TfNSW Reference: SYD18/01322/63

Departments Reference: SSD 9522 MOD 3

AMMENDED APPLICATION - SECTION 4.55 (2) MODIFICATION TO PROPOSED WAREHOUSE & LOGISTICS HUB - 657-769 MAMRE ROAD - KEMPS CREEK - SSD 9522-MOD 3

TURNING PATHS PLAN-SHEET 2
STAGE 1 INTERSECTION
MOD 3

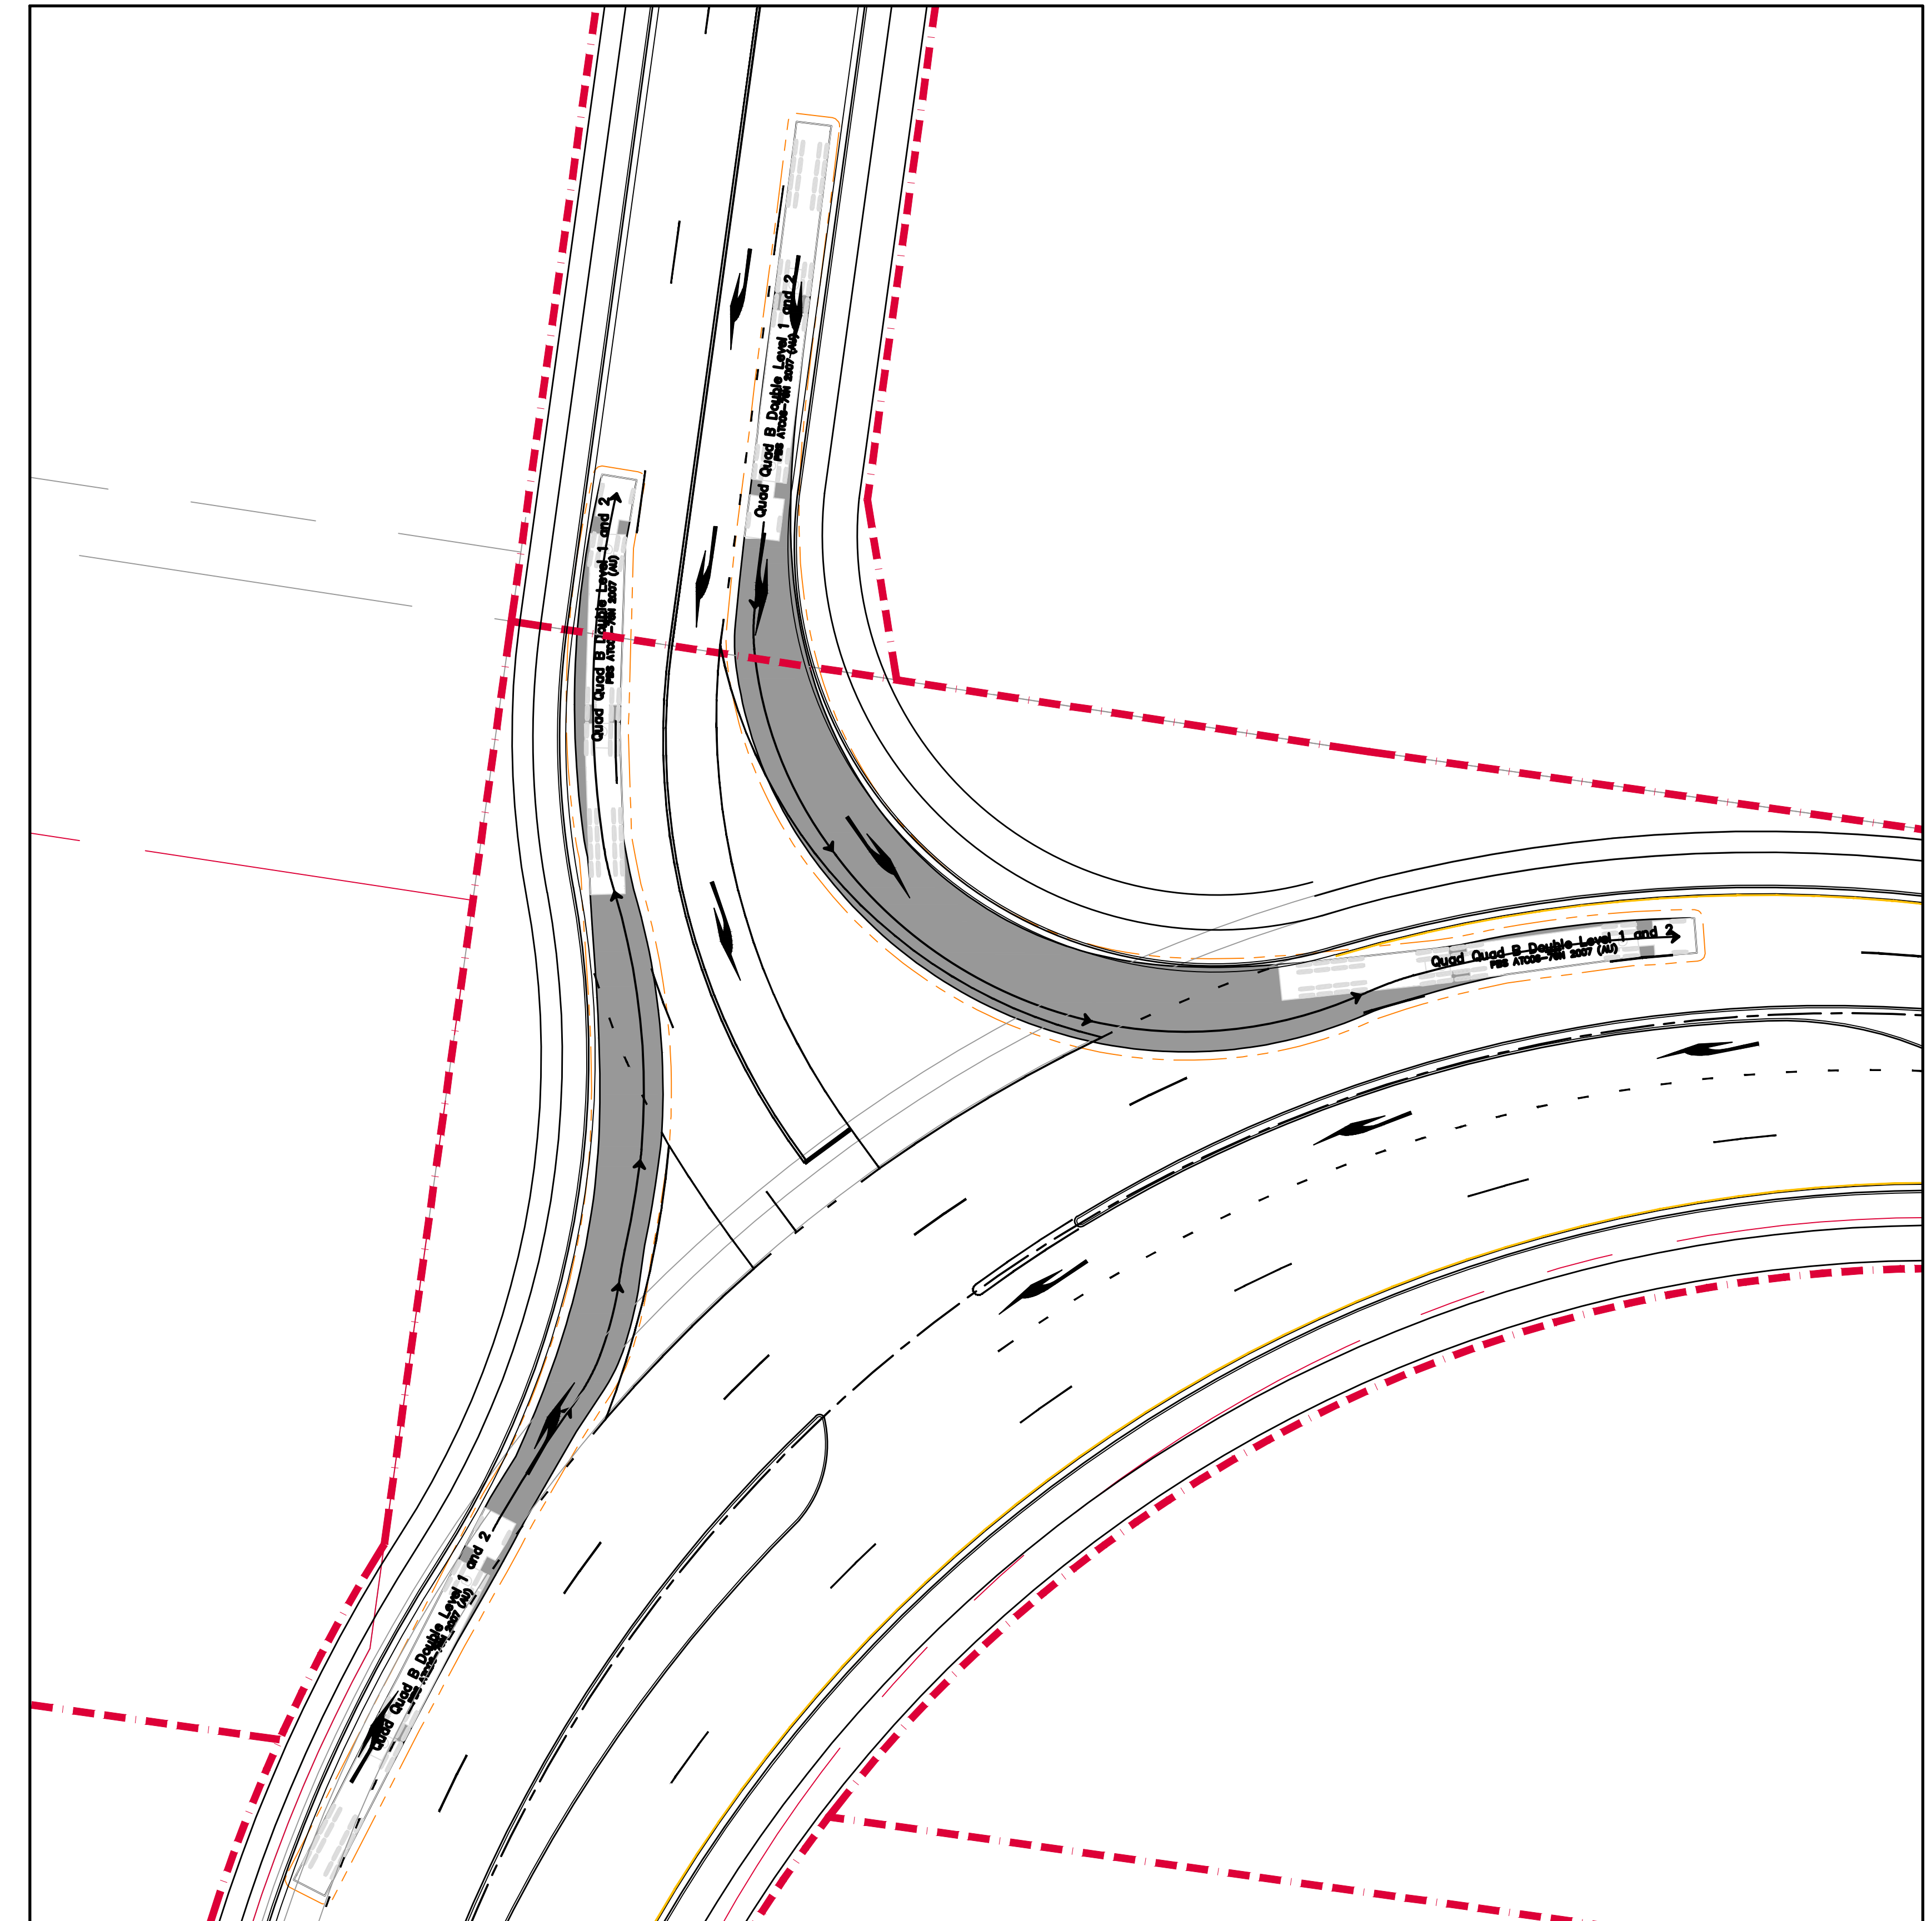
The proposed design for the future Southern Link Road ultimate intersection design is not supported by TfNSW. The location is a greenfield site and therefore the design should not be compromised by the surrounding proposed lot configuration.

The current plan has design elements that are non-conforming to current approved standards which would not be able to be designed out in further design stages. These design elements include but are not limited to, inadequate sight distance on approach to the intersection; below standard horizontal geometry for the northbound through movement; angled pedestrian crossings; high angled and tight swept paths etc. This is primarily due to the alignment of the northern leg of the intersection (Bakers Lane) which should be as close to 90 degrees with the Southern Link Road as possible. In addition TfNSW reiterates that only a double diamond would be supported for this location and any designs will need to ensure that a double diamond can be achieved.

Due to the abovementioned concerns TfNSW notes Condition B18 has not been adequately addressed. In this regard TfNSW does not support the removal of Condition B18. However, should the applicant not be able to provide a supported design for the Southern Link Road ultimate intersection design than the following condition is recommended:

Southern Link Road and Access Road 1 (south) ultimate intersection design will be designed and constructed as a T-intersection and access to Lots 1-4 will access Southern Link Road directly and be restricted to left in left out only from access road (north).
